RECOMMENDATION FOR PLANNING AND DEVELOPMENT COMMITTEE

REFUSAL

APPLICATION REF: 3/2024/1016

REGULARISATION OF WORKS INCLUDING EXTENSION TO GROUND FLOOR TO INCLUDE INTERNAL SECURE RESIDENTS CYCLE STORE WITH ROLLER SHUTTER DOOR; RE-INSTATE REAR BOUNDARY WALL TO 0.74M HIGH; ALTERATIONS TO REAR EXTERNAL STAIRCASE; UPVC WINDOWS AND DOORS TO FRONT, SIDE AND REAR; ALUMINIUM WINDOWS TO THE FRONT DORMER; SCREENING FEATURE TO THE REAR BALCONIES; GROUND FLOOR BIN STORE; CENTRAL CLADDING TO FRONT DORMER WINDOW ON THIRD FLOOR; ROOFLIGHTS; EXTERNAL LIGHTING SCHEME TO REAR AND TWO ELECTRIC CHARGING POINTS AT 1 TO 7 THE PICTURE HOUSE, GEORGE STREET, WHALLEY BB7 9TH

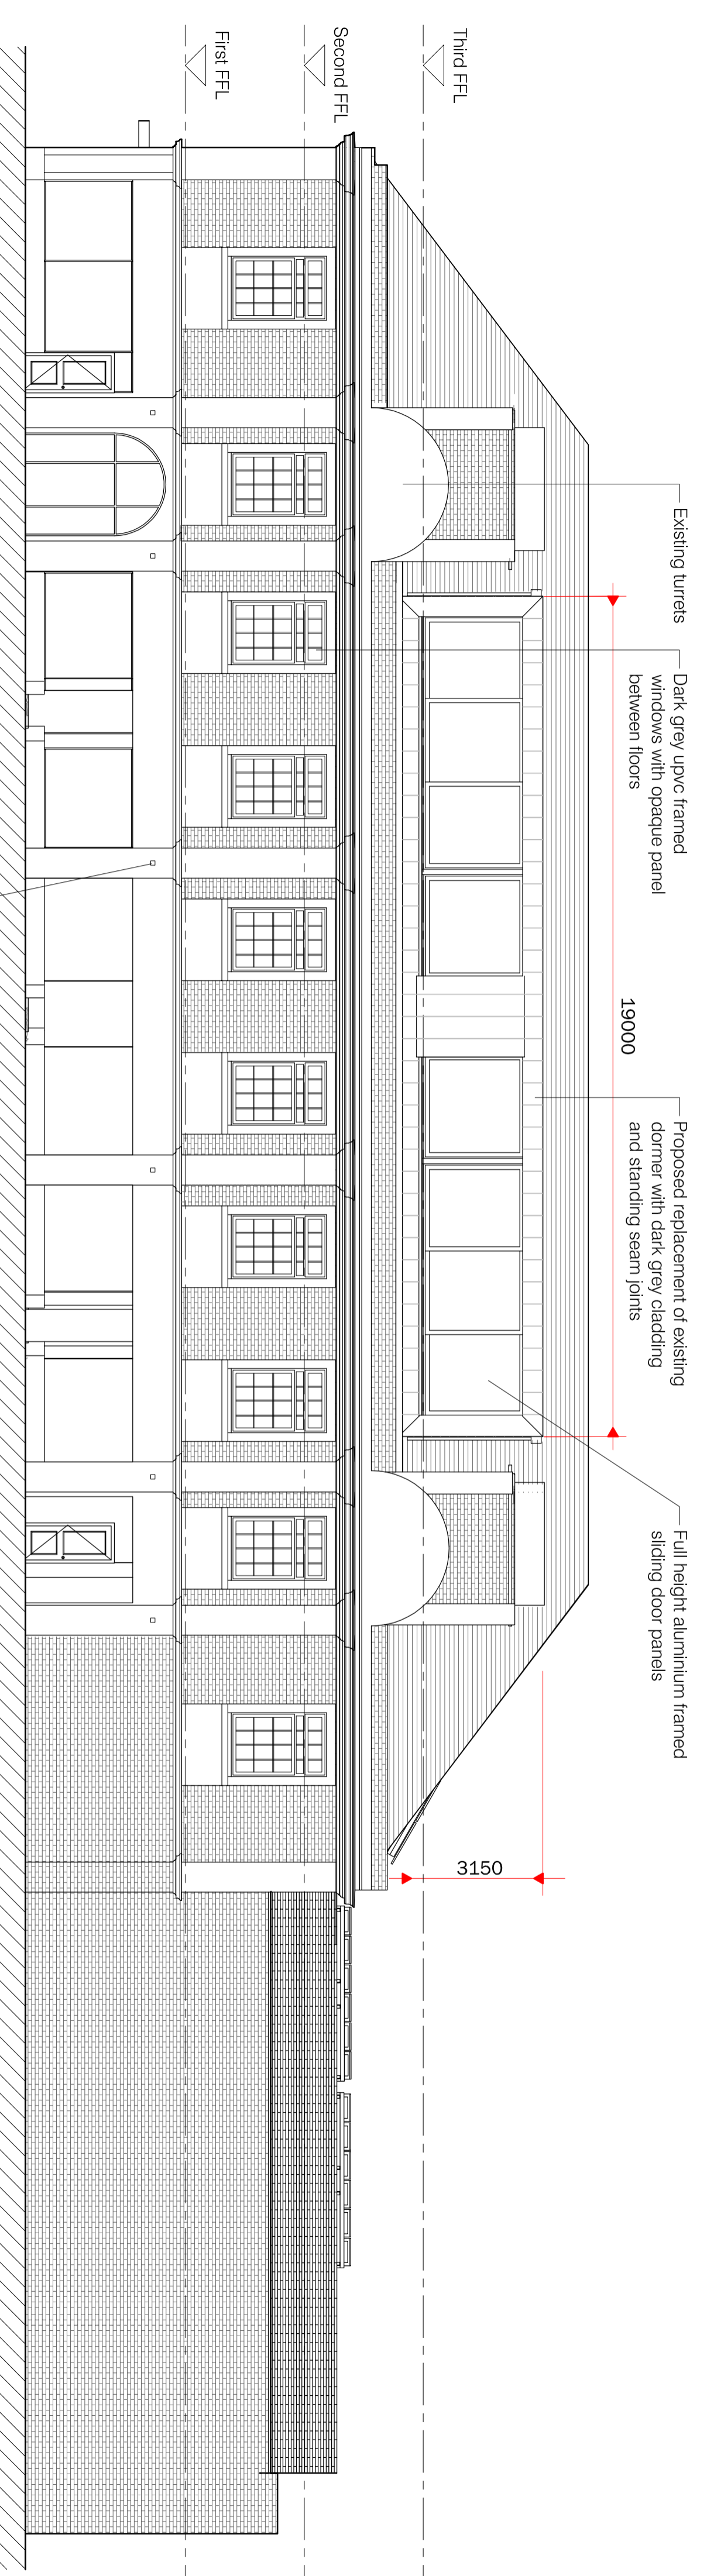
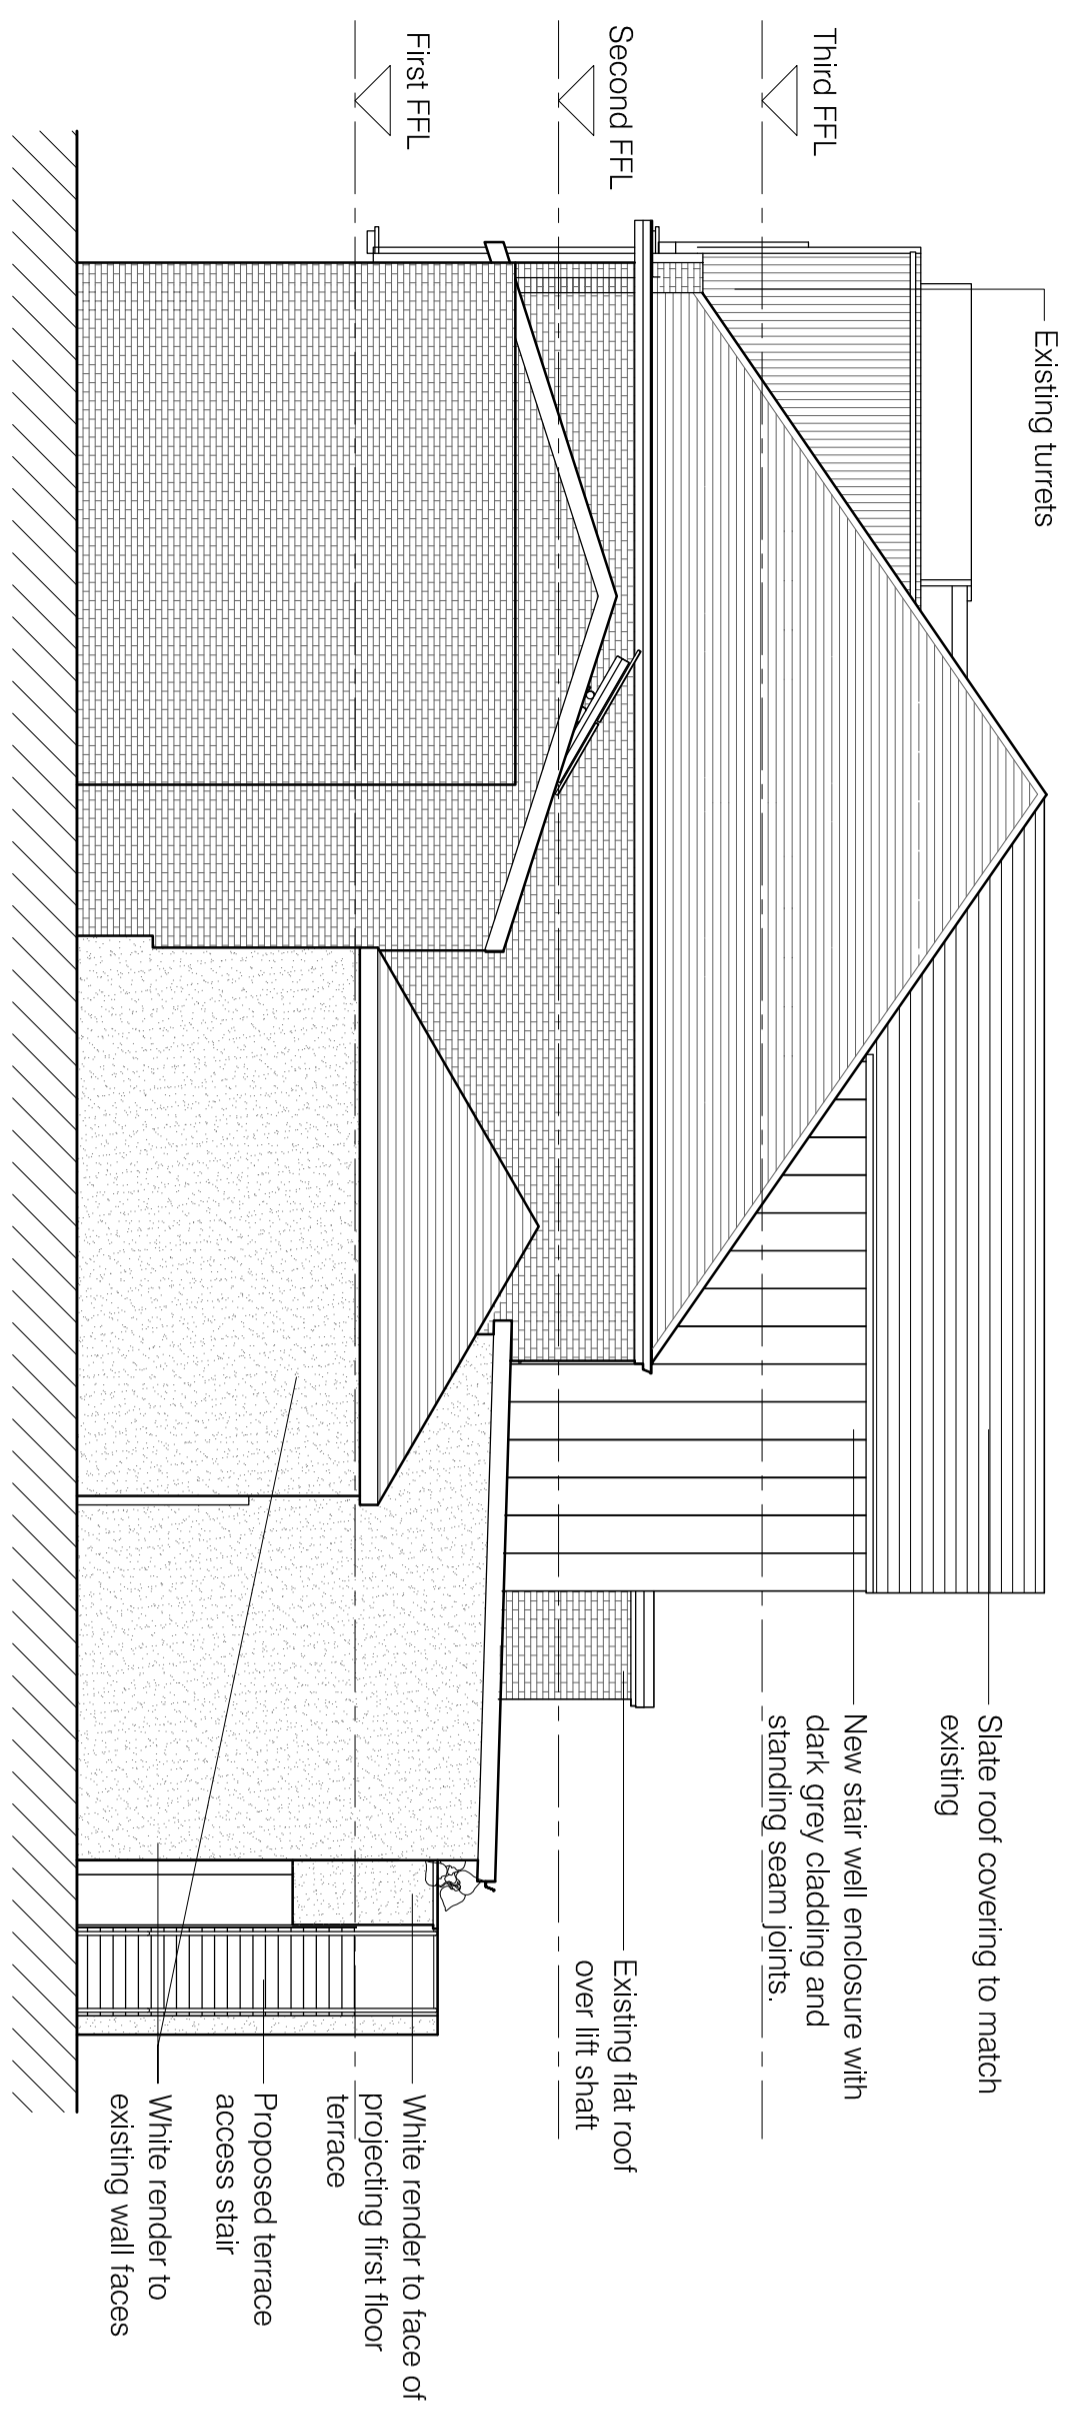
- 5.2.7 Of particular concern is the materials that have been used on the development. In terms of the UPVC windows, this use of modern bulky UPVC materials on prominent front, rear and side (east facing) elevations is not appropriate to this building of Townscape Merit or its setting within the conservation area and immediately adjacent to listed buildings. In this instance the side and rear elevations are as important as the frontage due to the public viewpoints along the public right of way to the rear of the site and the proximity of the listed cottages to the southwest of Church Lane.

- 5.2.9 The aluminium windows in the dormer to the North (front) elevation whilst different to that previously approved is more acceptable due to its slimmer aluminium frame. However a dark grey cladding panel has been installed between the windows and as a frame to the dormer. This same dark grey cladding has been used on the rear projecting gables / stairwell enclosure. This cladding alongside the windows in UPVC material is not considered to be sympathetic to the building when viewed from within the conservation area.
